Subject: New Suncadia, Phase 1, Division 15 (LPF-18-00006) Final Long Plat – Staff Review and Request for Additional Information

TO: Community Development Services
FROM: Taylor Gustafson, Environmental/Transportation Planner
DATE: September 28, 2018
SUBJECT: Public Works Review of Final Plat LP-18-00006

DATE : 2018-08-30 | JOB NO. 998-766-016-0002  
DRAWN BY: C.A.F./R.F.G. | SHEET 1 OF 5

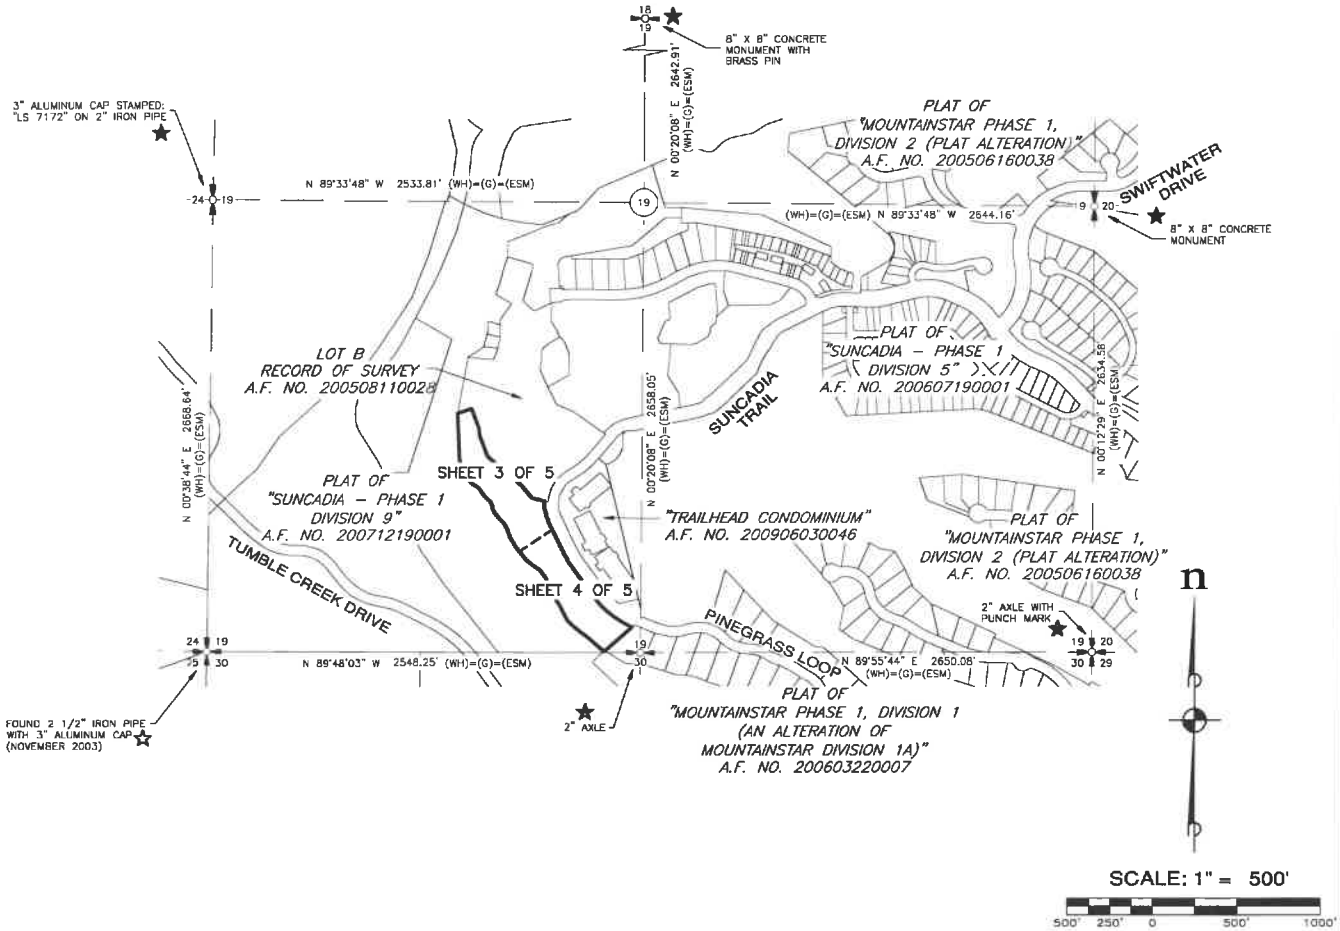
- Required Changes
 1. On sheet 1 the certificate is shown in two locations.
 2. Sheets 3 and 4 are missing the surveyor stamp.
 3. Suncadia Trail should include the ownership and surfacing (EX: Suncadia Trail, Private R/W-Paved).
 4. The additional R/W to be dedicated to Suncadia Trail should be labeled as "additional right of way herein dedicated."
 5. Sheet 4 includes a legend item "Found corner as noted". Please note what was found in the two locations containing this symbol.

1. On sheet 1 the Recording Certificate is shown in two locations.
2. Sheets 3 and 4 are missing the surveyor stamp.
3. Suncadia Trail should include the ownership and surfacing.
EX: Suncadia Trail (Private R/W – Paved)
4. The additional R/W to be dedicated to Suncadia Trail should be labeled as "(additional right of way herein dedicated)"
5. Sheet 4 includes a legend item "Found corner as noted". Please note what was found in the two locations containing this symbol.
